Re: BusConnects Clongriffin to City Centre Core Bus Corridor Scheme
County Dublin

**Submission on proposed Clongriffin to City Centre Core Bus Corridor Scheme -
Case reference: CH29N.313279**

On behalf of its members, DWCA wishes to make the following comments in relation to the proposed BusConnects Core Corridor passing through our area. Our comments refer to design details contained in Sheets 16, 17 and 18 of the General Arrangement drawings and corresponding Landscape Arrangement drawings.

Programme Title <b>BUSCONNECTS DUBLIN CORE BUS CORRIDORS INFRASTRUCTURE WORKS</b>					
Drawing Title <b>CLONGRIFFIN TO CITY CENTRE CORE BUS CORRIDOR SCHEME GENERAL ARRANGEMENT</b>					
Drawing File Name BCIDA-ACM-GFO GA-0001 XX 00-DR-CR-0018			Sheet Number 18 of 21	Status A	Rev M01

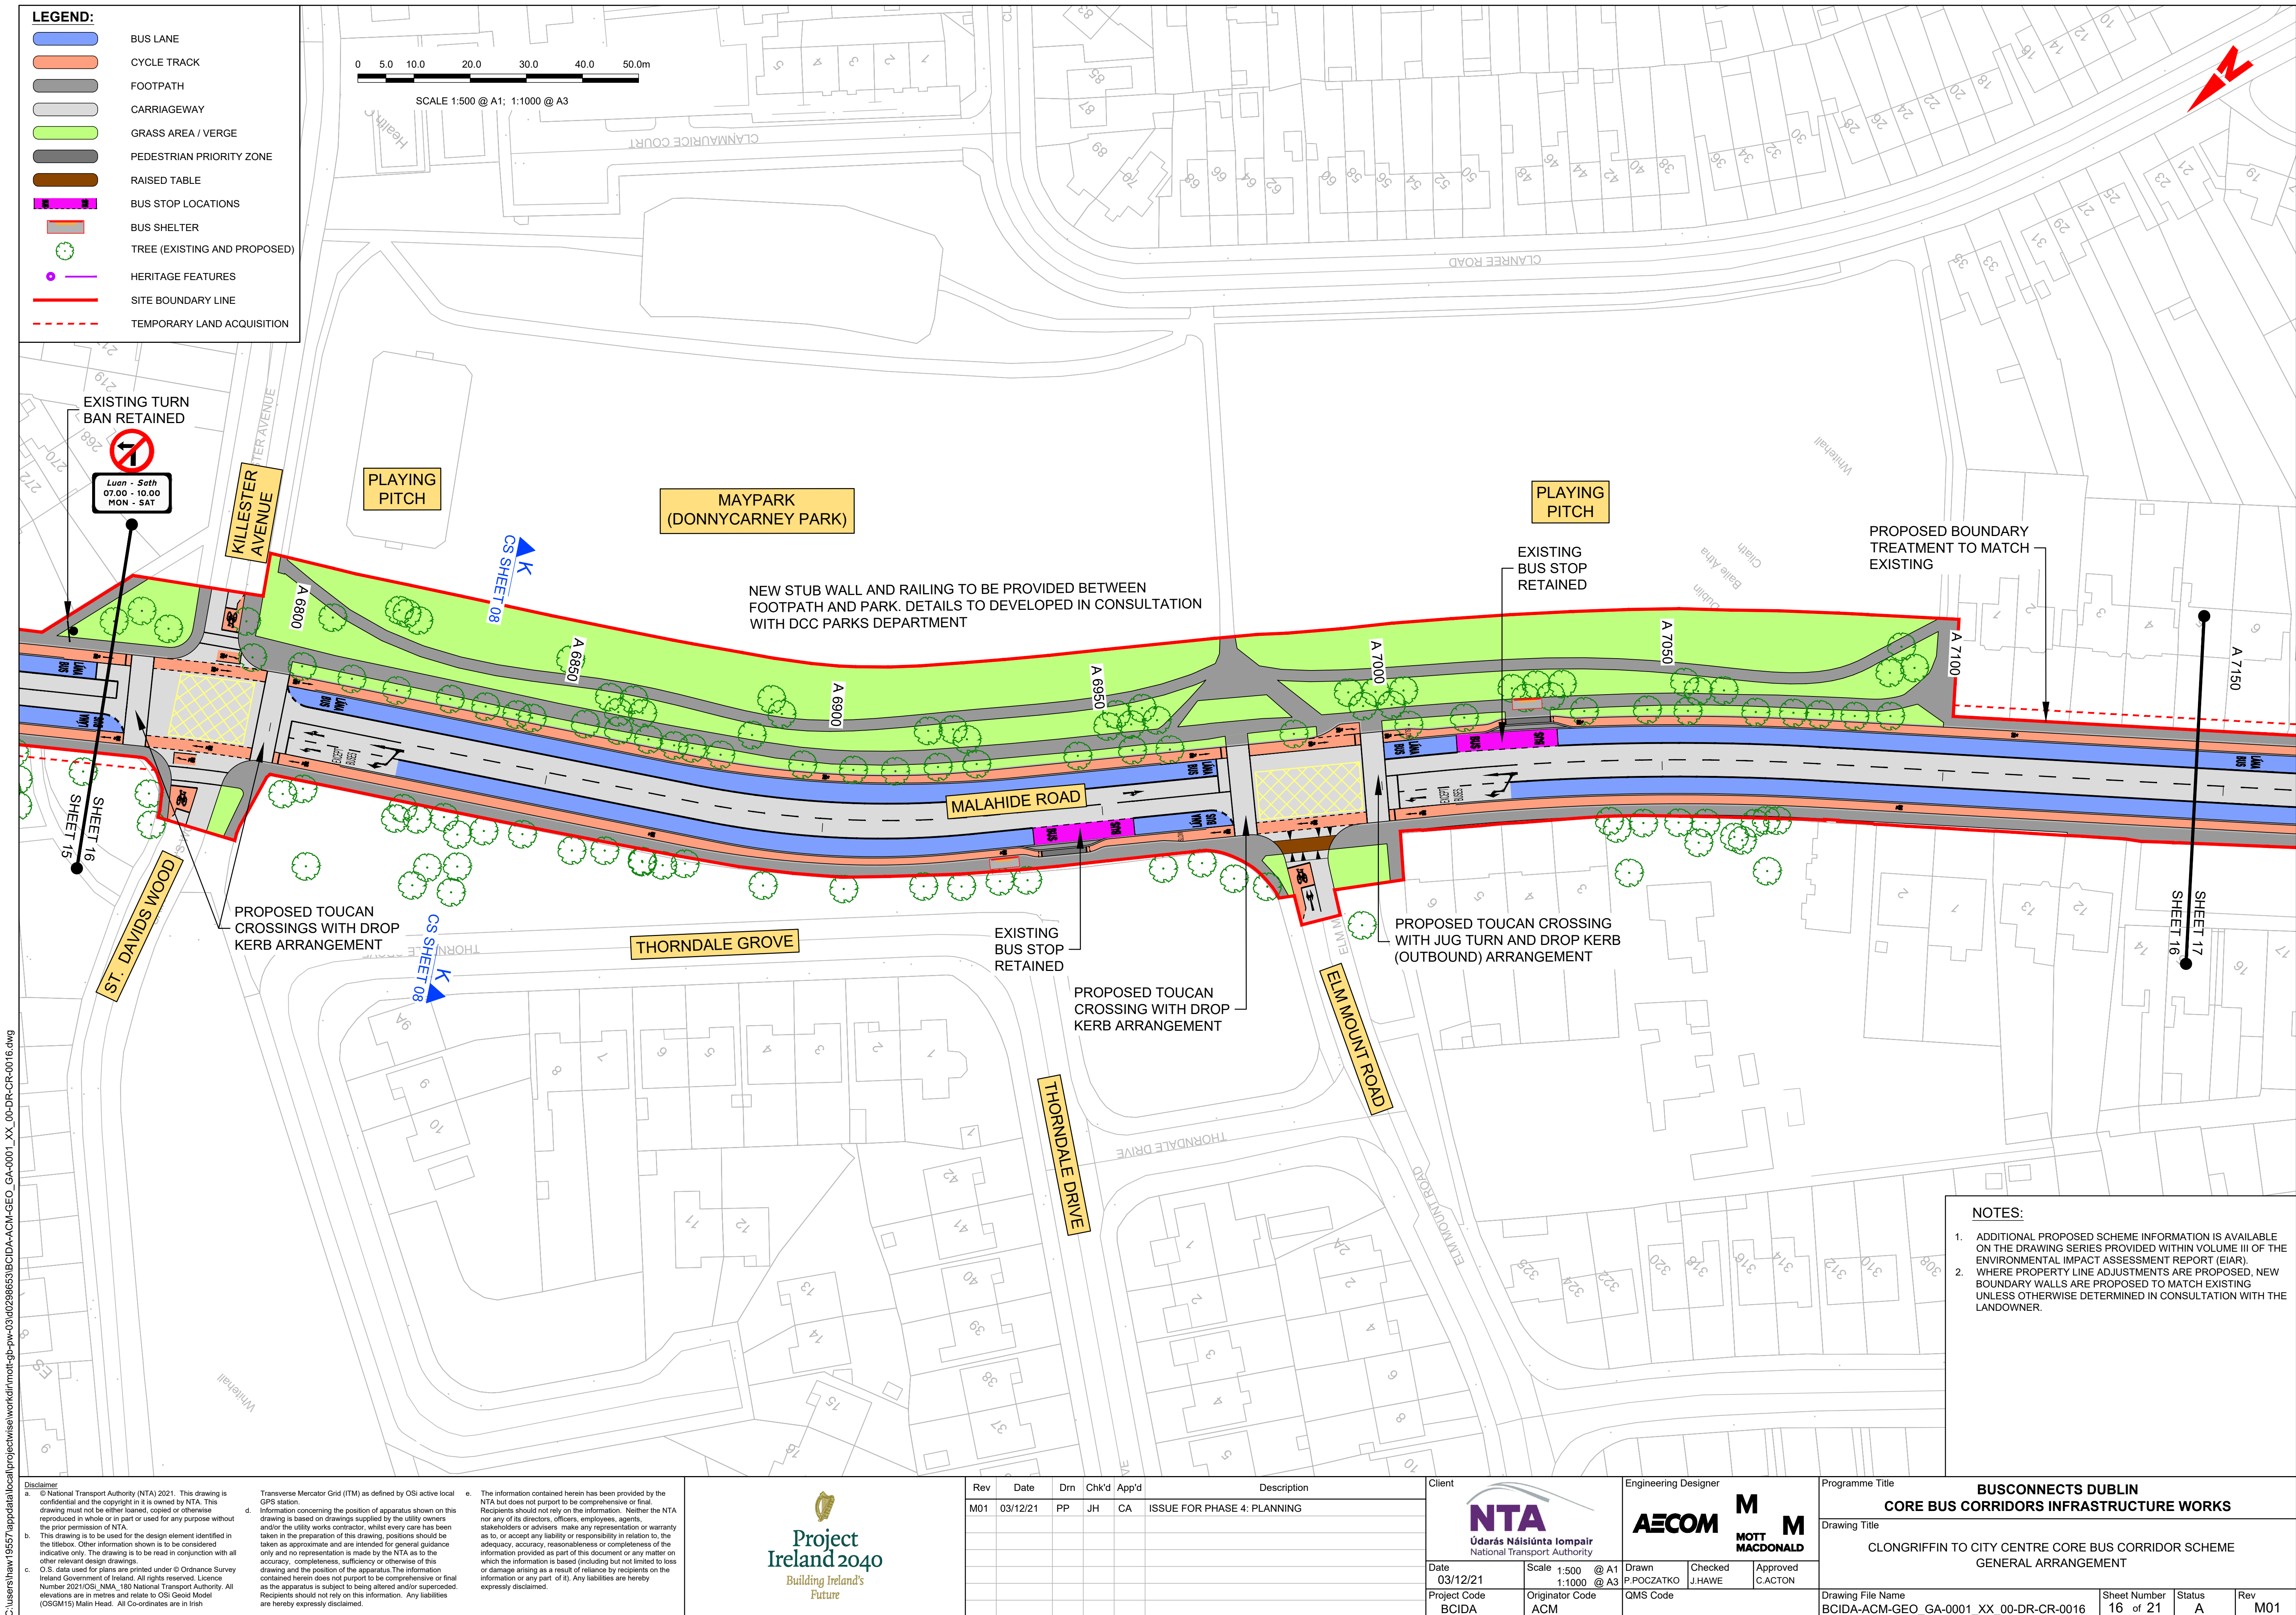
2. There is some disquiet among older members of the community at the **relocation of the outbound bus stop 672** from its current position to south of the entrance to Casino Park/Cherry Mount. This is a less convenient location for residents of Donnycarney Road or Belton Park Road.

3. An **area of grass and trees** is proposed from 109 Malahide Road to the junction with Donnycarney Road. If built, this green area would sit directly to the front of 4 existing shops and so makes no sense. Furthermore, the arrangement for this area, with revised parking and changes to the footpaths will remove the existing vehicular access lane alongside 109 Malahide Road. This lane serves a number of houses along the lane. The design of this area should be reconsidered.

4. We ask that the recently installed **Eir advertising unit** close to the junction of Donnycarney Road is removed as part of these works as it will now impede pedestrians due to the narrowing of the footpath.

5. We ask that the **5 no. flower basket poles** installed by the local community to the front of the shops on Malahide Road are retained and incorporated into the new layout.

8. **Vehicle access arrangements and off-street parking** for houses along Malahide Road from No. 127 to 149 should be clarified. Some of these houses have existing off-street parking arrangements. Will this change with the introduction of a kerb-separated cycle lane? Please also clarify for Nos 179 to 187 Malahide Road (north of Collins Avenue West junction).
